Application by National Highways for the Lower Thames Crossing
The Examining Authority's third written questions and requests for information (ExQ3)
Issued on 14 November 2023

Responses are due by Deadline 8: Tuesday 5 December 2023.

EXISTING BASEMENT PLAN

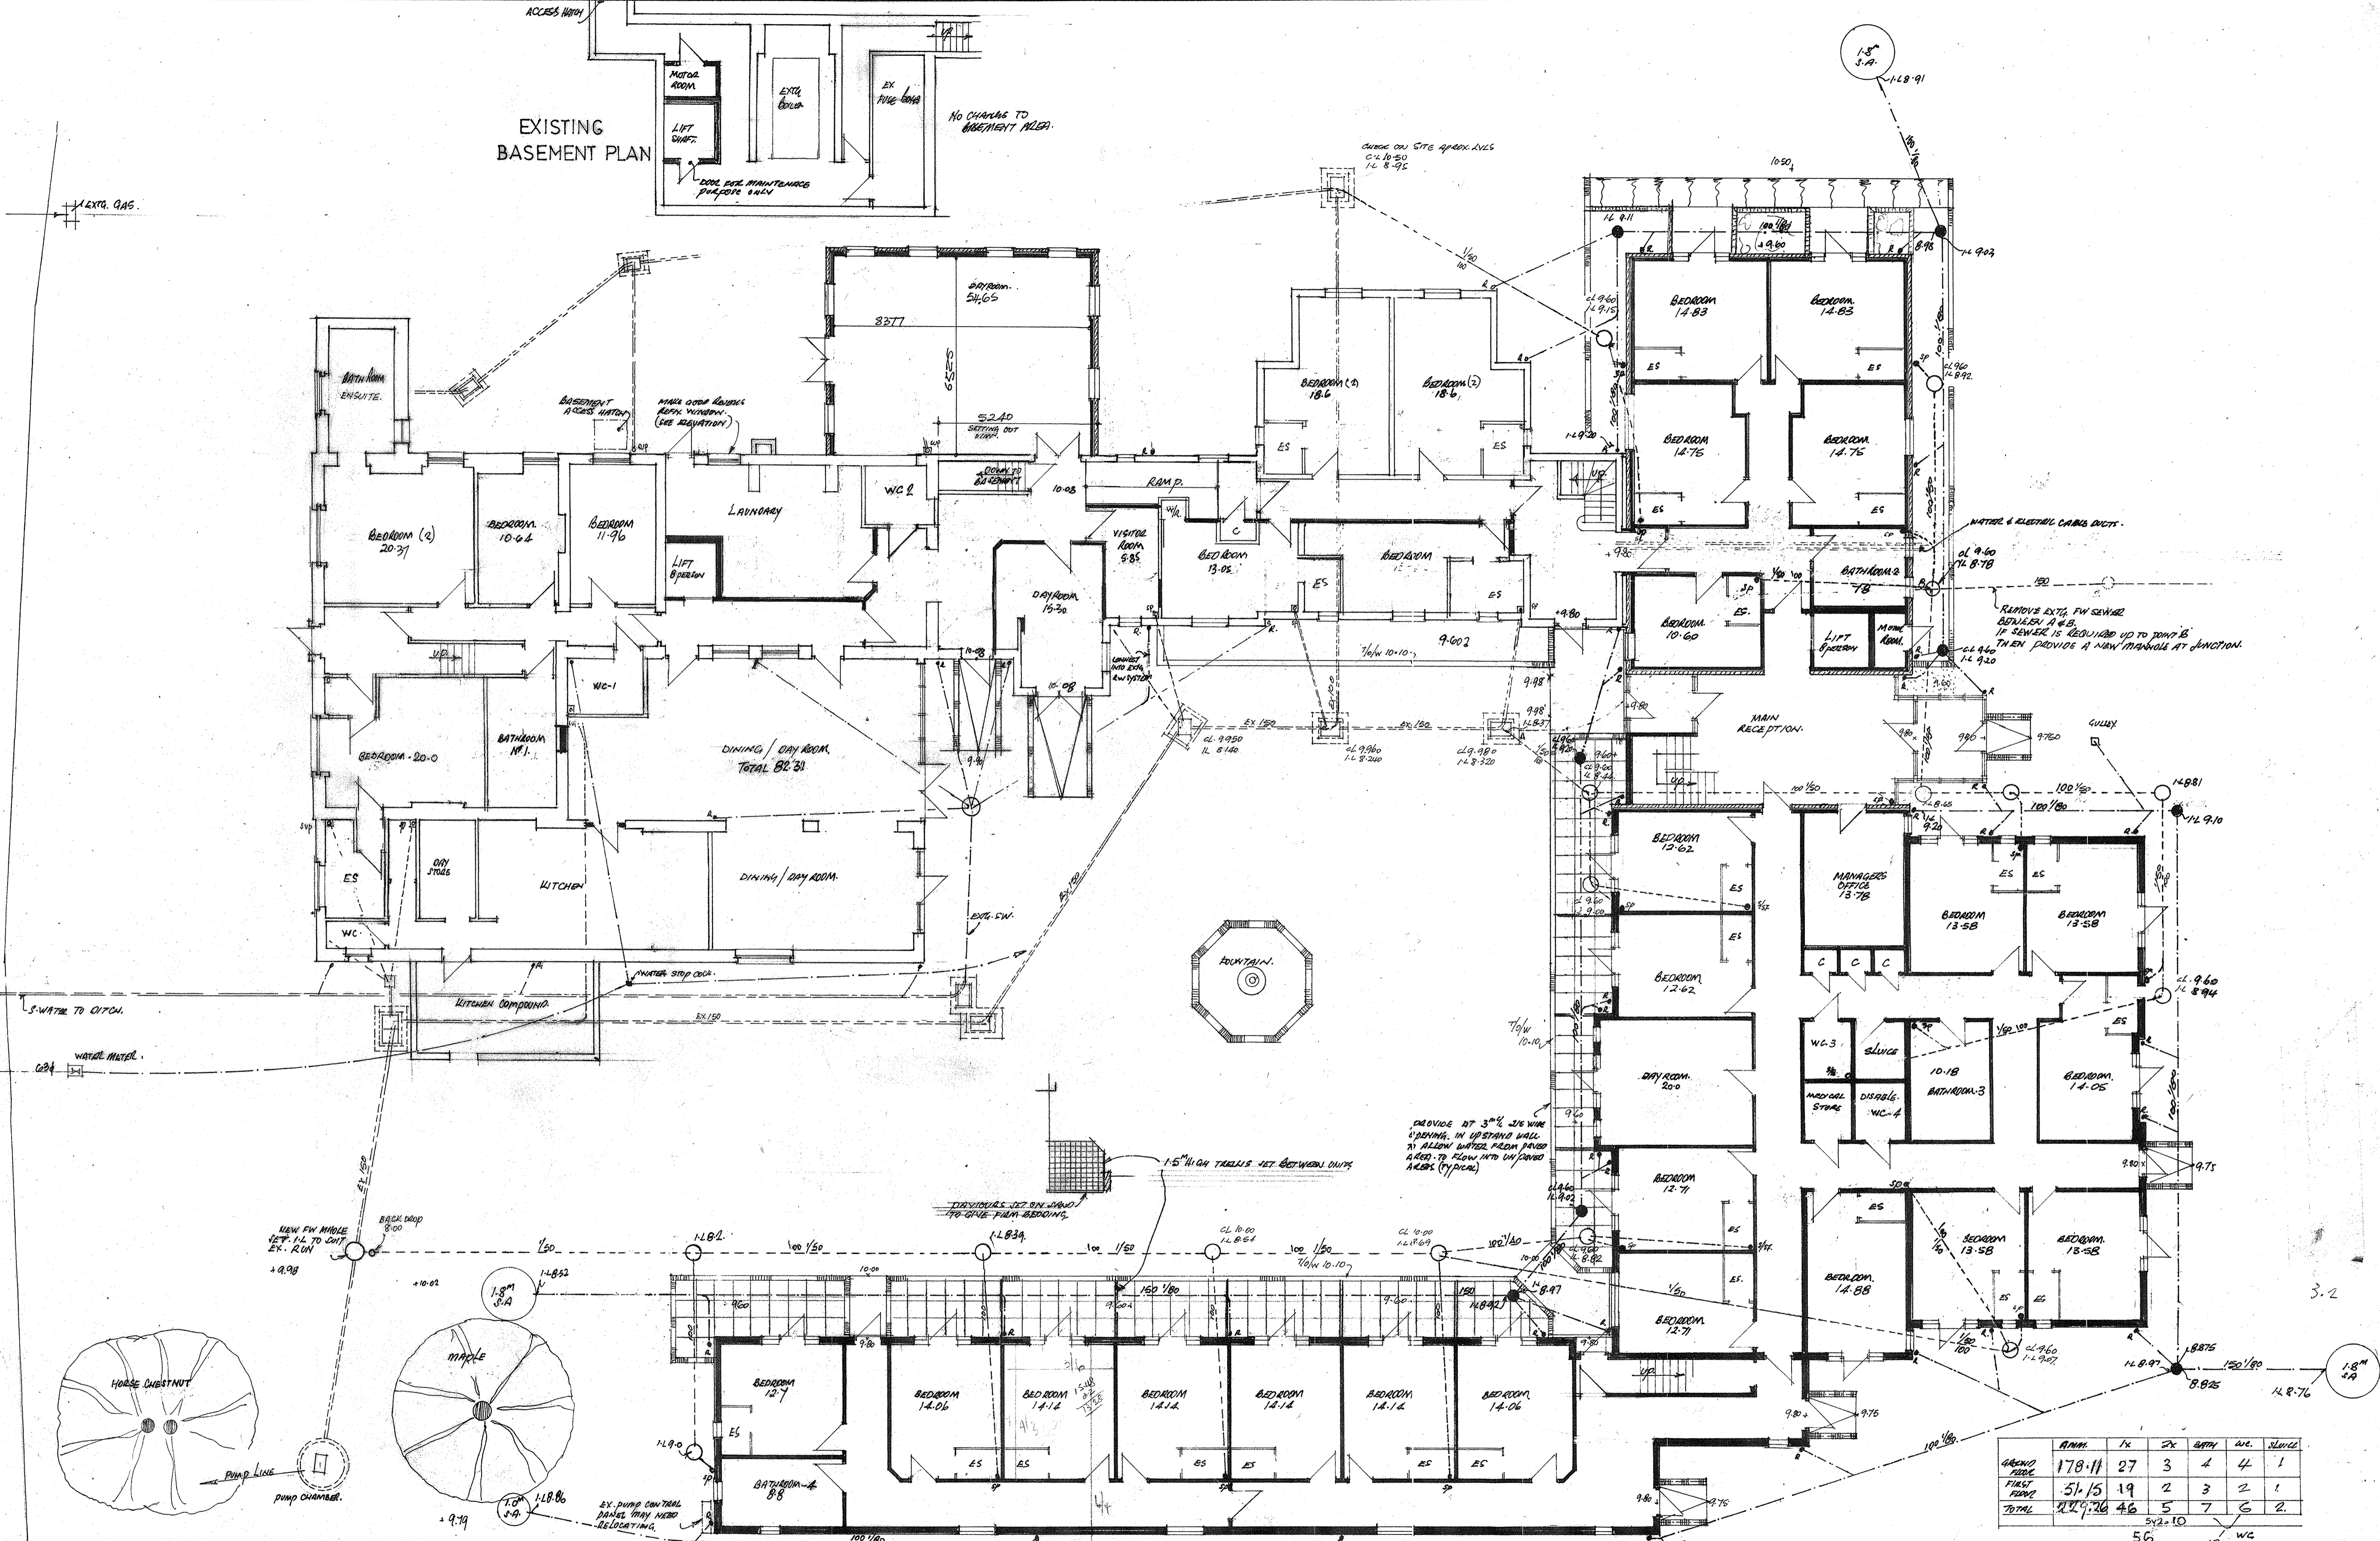
ExQ3	Question to:	Question:
Q10.1.15	Applicant	<p>Landscaping effect on proposed ditches</p> <p>Where proposed landscaping directs surface flow to a “proposed drainage ditch” such as the embankment at the Whitecroft Care Home, as shown in the Document Deadline 5 Submission - 9.123 Whitecroft Care Home Cross-sections [REP5-092]:</p> <ul style="list-style-type: none"> • has a site-specific risk assessment been undertaken to determine the risk of overtopping and affecting land and property outside the highway boundary, with the appropriate maintenance regime? • if one has not been considered necessary what was the process that came to that conclusion? • Are there any locations that may benefit from such considerations and where would the results of the analysis be recorded, and mitigation suggestions/requirements secured?
Q10.1.16	Applicant	<p>Future maintenance of proposed ditches</p> <p>Although reference has been made to the appropriate DMRB maintenance standards in the Applicant’s response in ExQ2 10.1.3 [REP6-112], can the ExA be directed to the location of the evidence:</p> <ul style="list-style-type: none"> • that sufficient land has been reserved within the Order Limits to allow appropriate and safe access to future operational staff to undertake these tasks; • for the plant that has been assumed to be considered necessary to be used to meet the requirements of the future maintenance laid down in the DMRB; and, • the proposed access routes that meet the proposed plant’s requirements? <p>If the maintenance operation has not been considered at this stage, can the Applicant provide the location of the information showing that there is sufficient space provided within the Order Limits to allow the maintenance work, and access to the relevant areas, to be safely undertaken?</p>
